<input type="checkbox"/> Sidewalk Waiver (Form V2)		
<b>SITE PLANS</b>		<input type="checkbox"/> Waiver to IDO (Form V2)	<b>APPEAL</b>
<input type="checkbox"/> DRB Site Plan (Form P2)	<input type="checkbox"/> Waiver to DPM (Form V2)	<input type="checkbox"/> Decision of DRB (Form A)	
<b>BRIEF DESCRIPTION OF REQUEST</b>			
Administrative Amendment to approved site development to relocate a transformer approximately 10' and to delete several light poles at the south property line.

<b>FOR OFFICIAL USE ONLY</b>					
Case Numbers	Action	Fees	Case Numbers	Action	Fees
SI-2020-000179	AA				
Meeting Date:				Fee Total:	
Staff Signature:			Date:	Project # PR-2018-001346

**RE: Project number BP-2018-001346, Mixed Use Development, Alameda & San Pedro NE, specifically Tin Can Alley, 6110 Alameda NE**

- REVISIONS:**
- 1 7-1-19 UPDATED CODE DATA
 - 2 7-18-19 PERMIT COMMENTS
 - 3 4-7-20 LIGHT POLES, TRANSFORMER
 - 4 4-20-20 AA FILE NO. SI-2020-00038

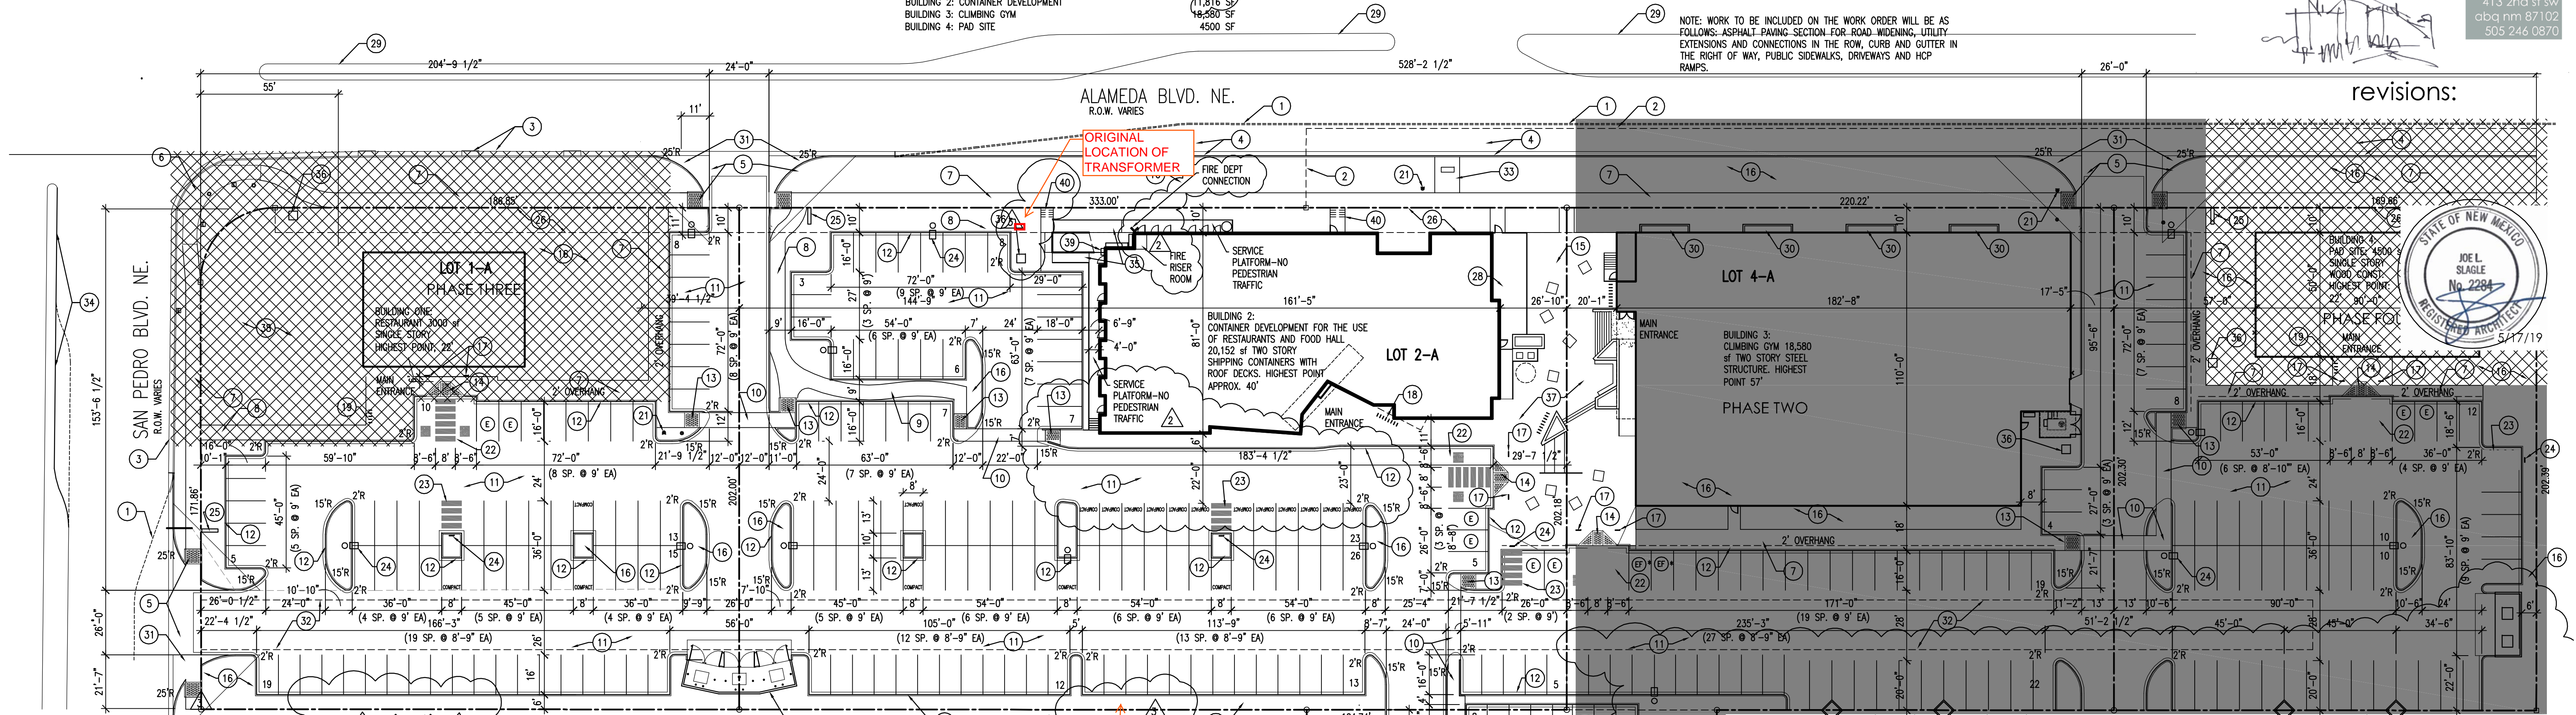
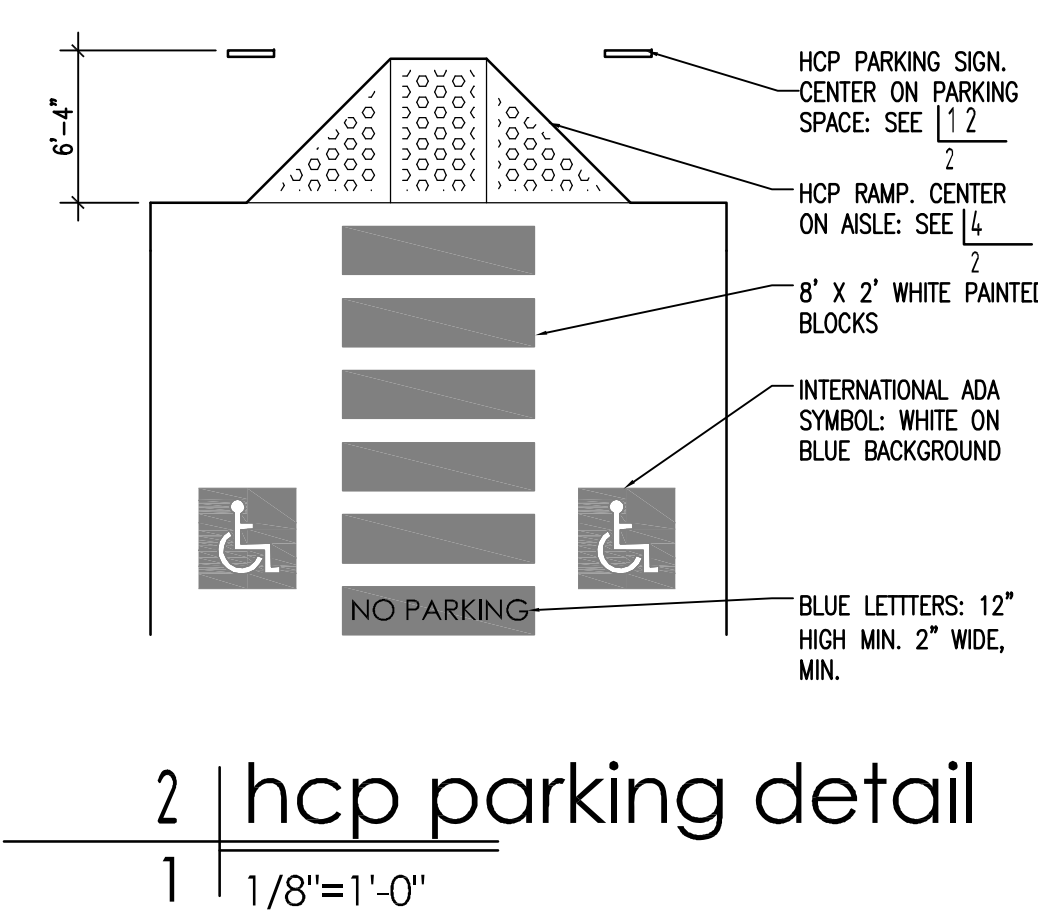
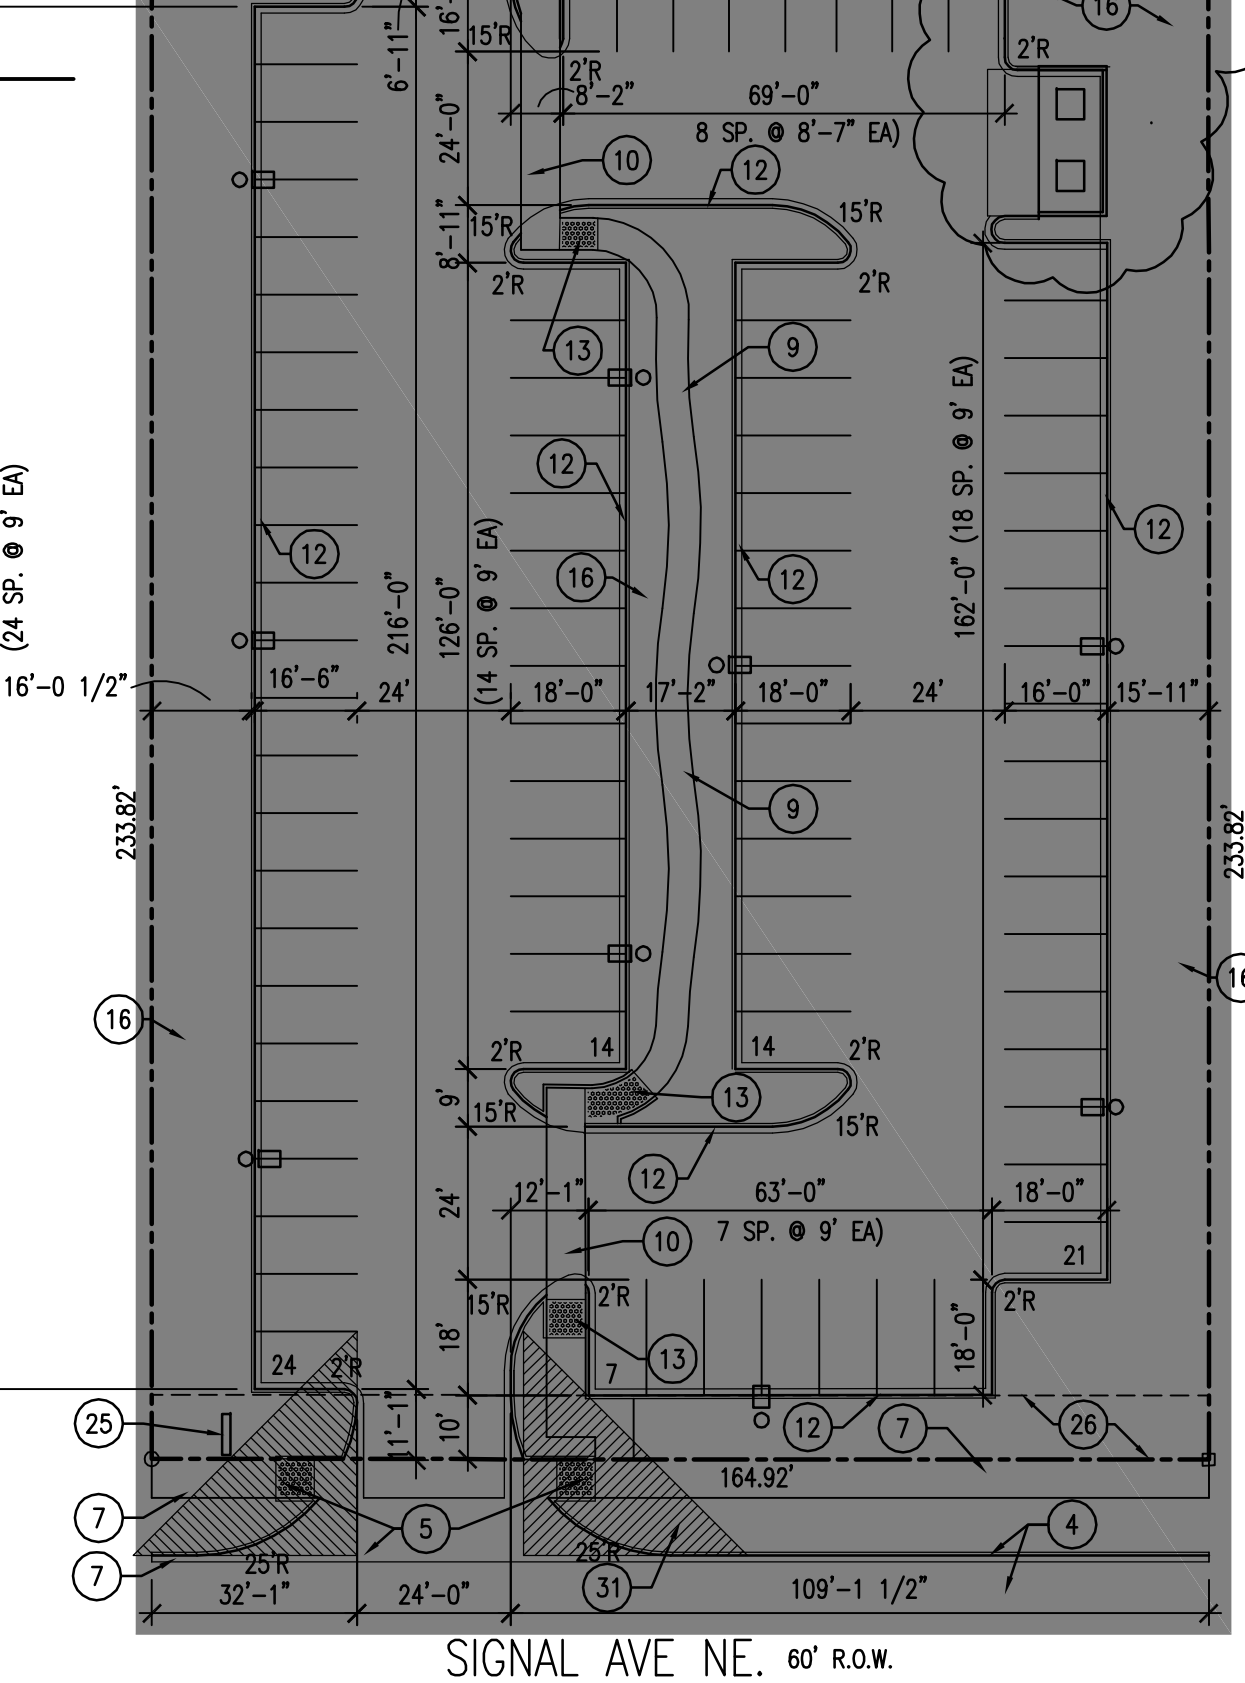
1. The transformer serving Tin Can Alley was originally shown in the 10' utility easement at the north property line. PNM requested that the transformer be relocated outside the easement so it was moved approximately 10' to the south which required the removal of one parking space. The parking provided still exceeds the requirement.
2. Several light poles along the south property line have been deleted because the poles located in the islands in the center area of the parking lot provide the required footcandle level as determined by the illumination analysis.
